from
**Southern
Water**

Your ref
FG/127/20/PL

Proposal: Retrospective application for the demolition of 3 No. existing buildings & erection of replacement workshop & machinery store building (amended design & siting to FG/37/17/PL). This site is in CIL Zone 5 (Zero Rated) as other development.

Site: FG/127/20/PL: - Onslow Caravan Park Onslow Drive Ferring BN12 5RX.

DRAINAGE PLAN

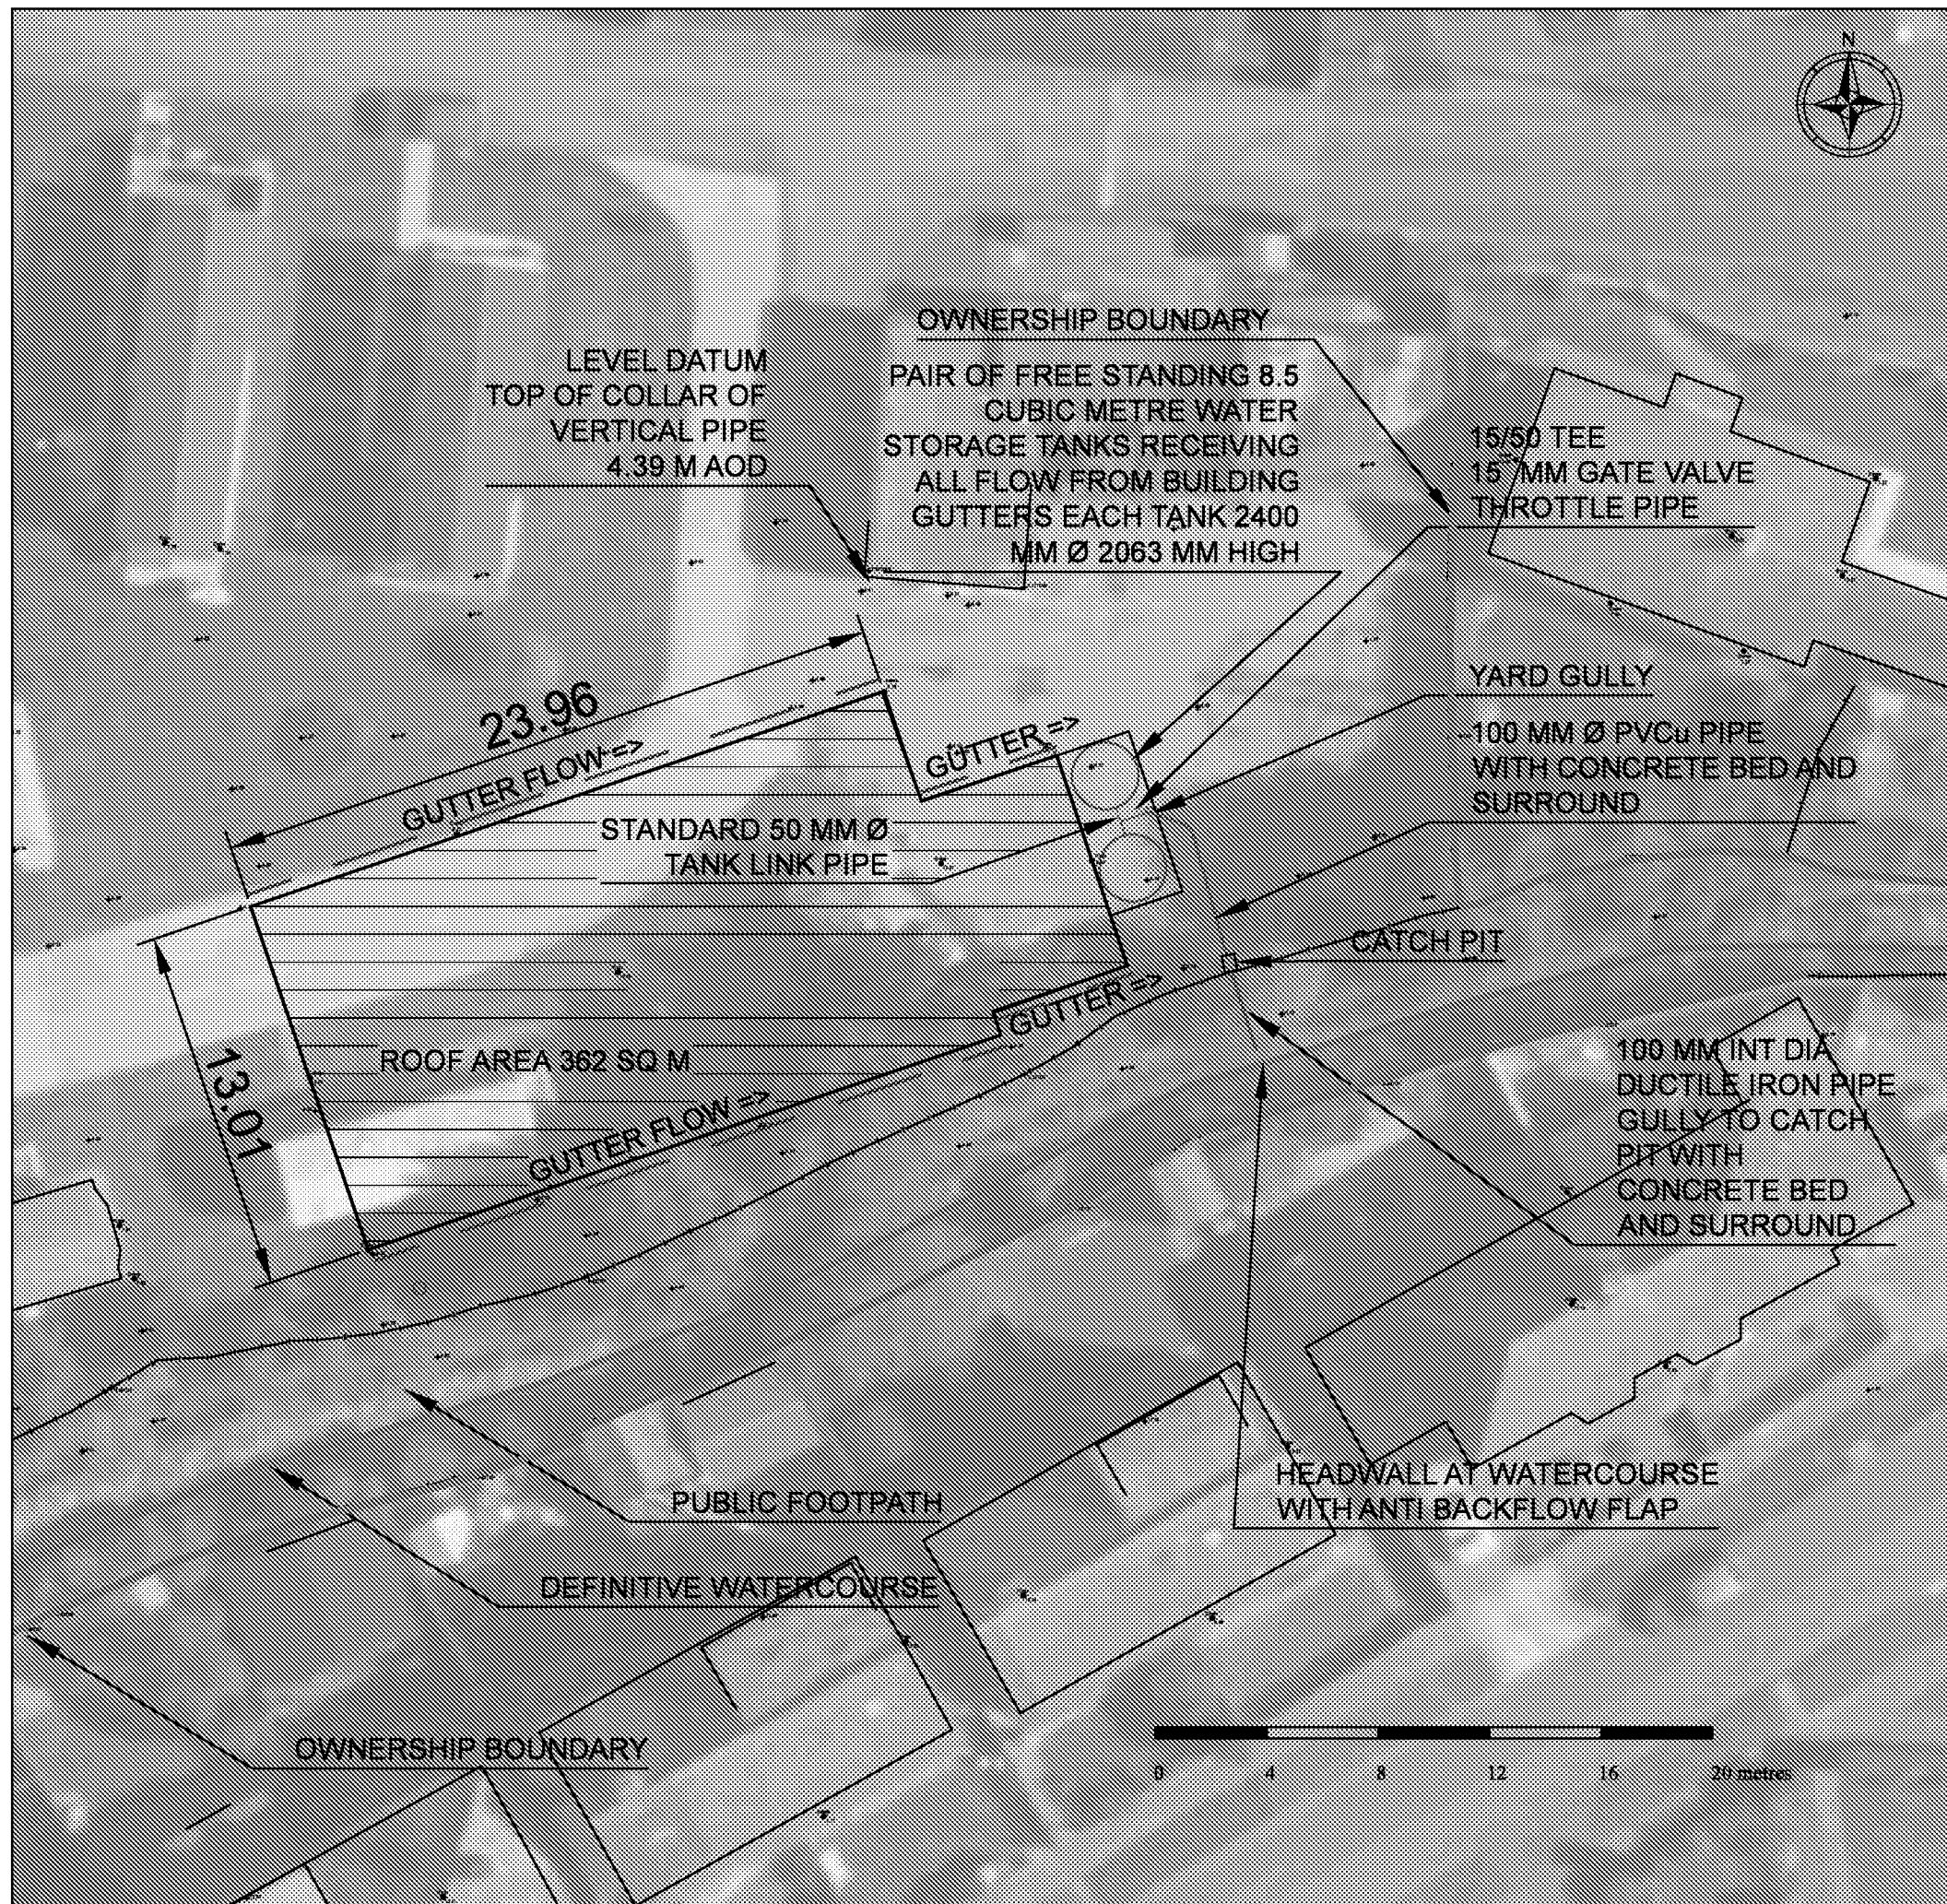
Please see the attached extract from Southern Water records showing the approximate position of our existing public foul sewer within the access. The exact position of the public foul sewer asset must be determined on site by the applicant.

- The 225 mm public foul sewer requires a clearance of 3 metres on either side of the gravity sewer to protect it from construction works and to allow for future access for maintenance.
- No development or tree planting should be carried out within 3 metres of the external edge of the public gravity sewer without consent from Southern Water.
- No soakaway, swales, ponds, watercourses or any other surface water retaining or conveying features should be located within 5 metres of a public sewer.
- All existing infrastructure should be protected during the course of construction works.

The Council's technical staff and the relevant authority for land drainage consent should comment on the adequacy of the proposals to discharge surface water to the local watercourse.
